City of Portland, Maine - Building or Use Permit Application

| Permit No: 09-1049 | | Issue Date: | | CBL: 388A A055001 | |
| Location of Construction: 56 QUIET LN | | Owner Name: LEGERE JERRY W & CHRISTINE C | | Owner Address: 56 PINELOCH DR | |
| Proposed Project Description: Single Family Home w/ 4 bedrooms, 2¾ baths & 2 Car Garage | | Permit Fee: \$2,595.00 | | Cost of Work: \$250,000.00 | |

Grading Name: GRADING AND UTILITY PLAN

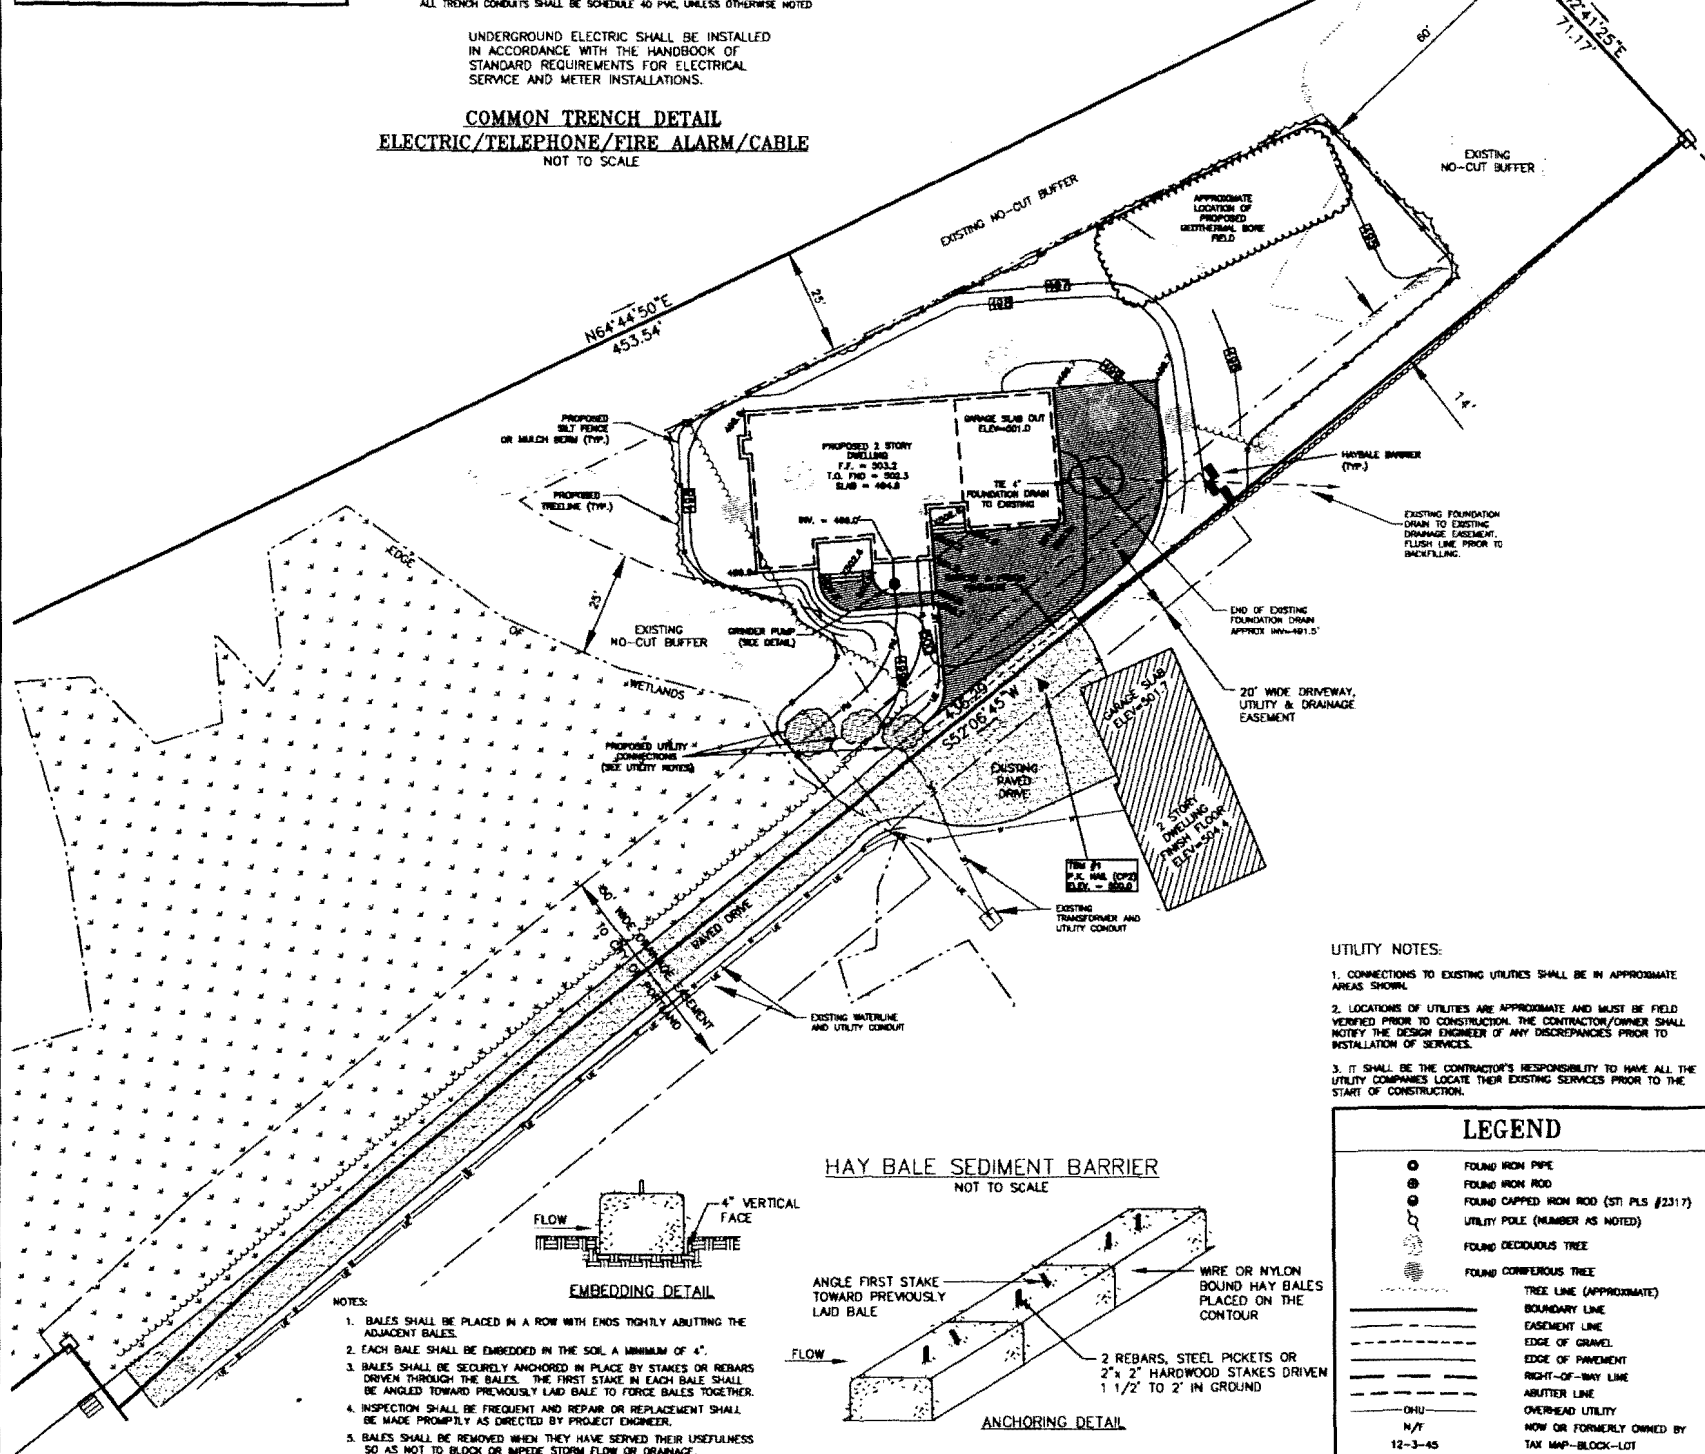
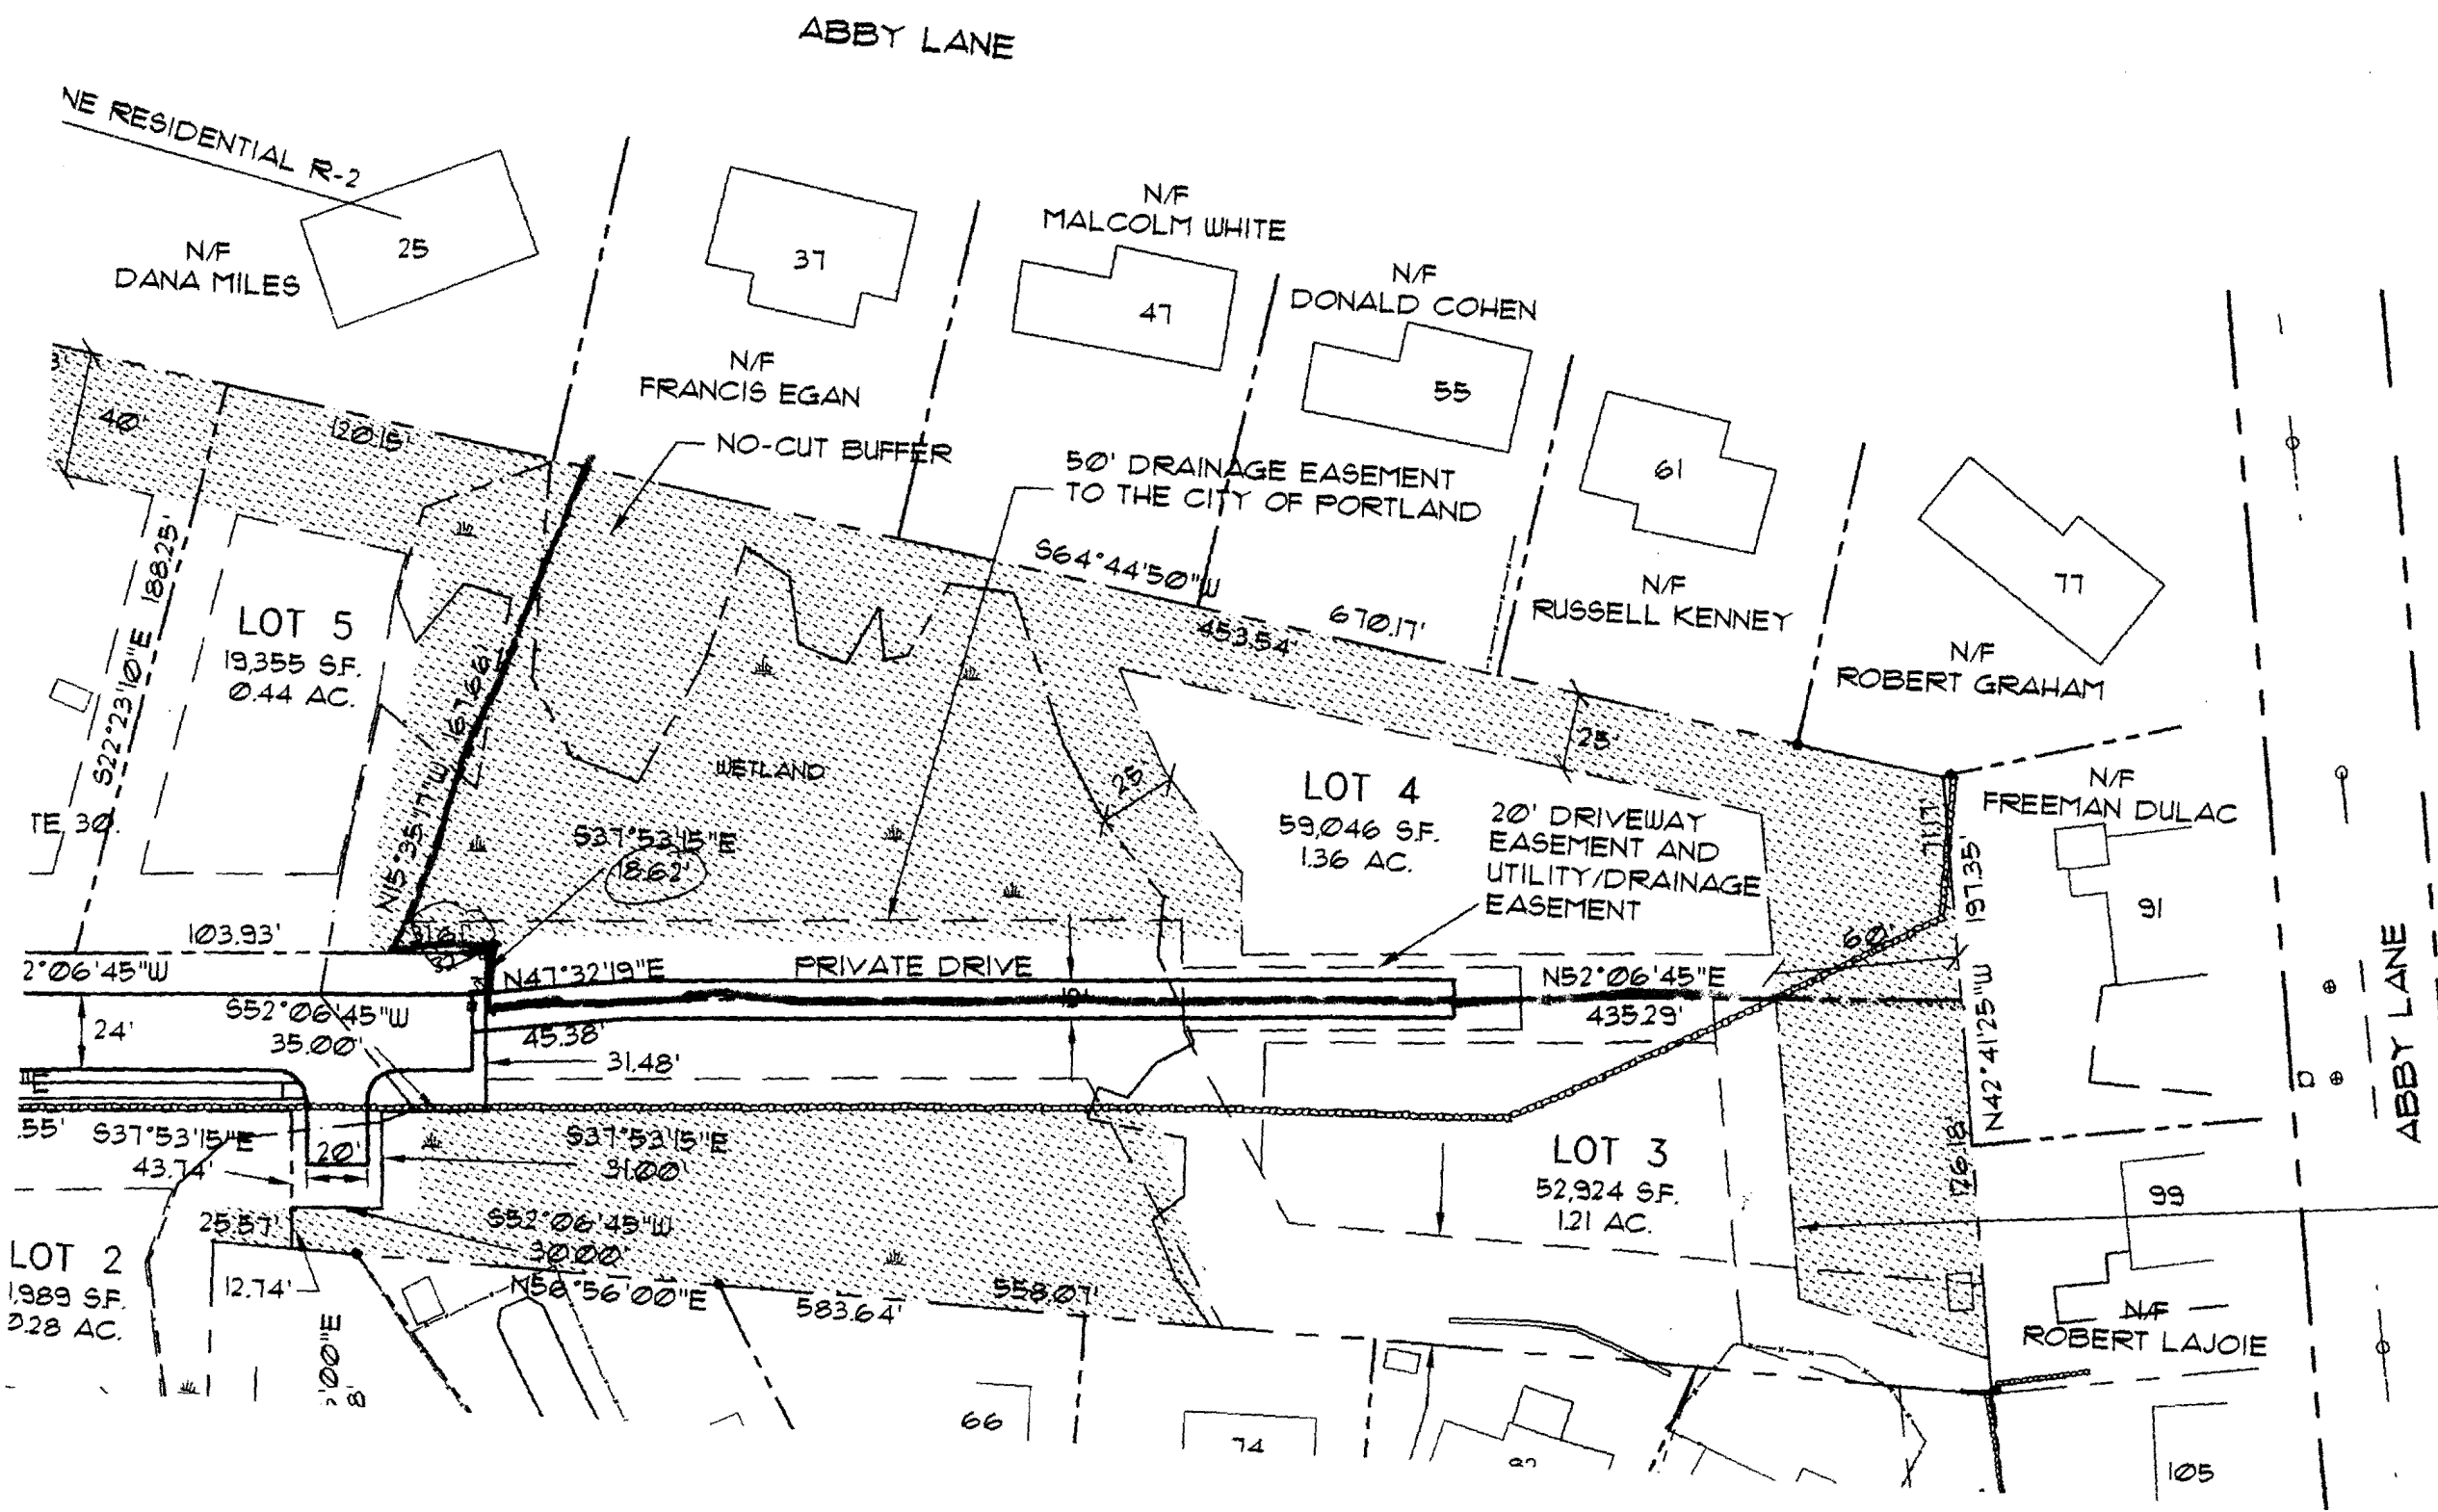
9/25/2009-amachado: Front corner of the siteplan is cut off. Need to have complete lot on siteplan to check front setback & street frontage. Siteplan doesn't show the three season porch. Waiting for Phil to review application to see if he needs anything.

10/8/2009-amachado: Checked frontage for lot on original subdivision plat. The lot has 50,23' of frontage. Moving permit forward for building review, but not signing off until receive complete siteplan with 3 season porch.

10/23/2009-amachado: Received full size revised site plan.
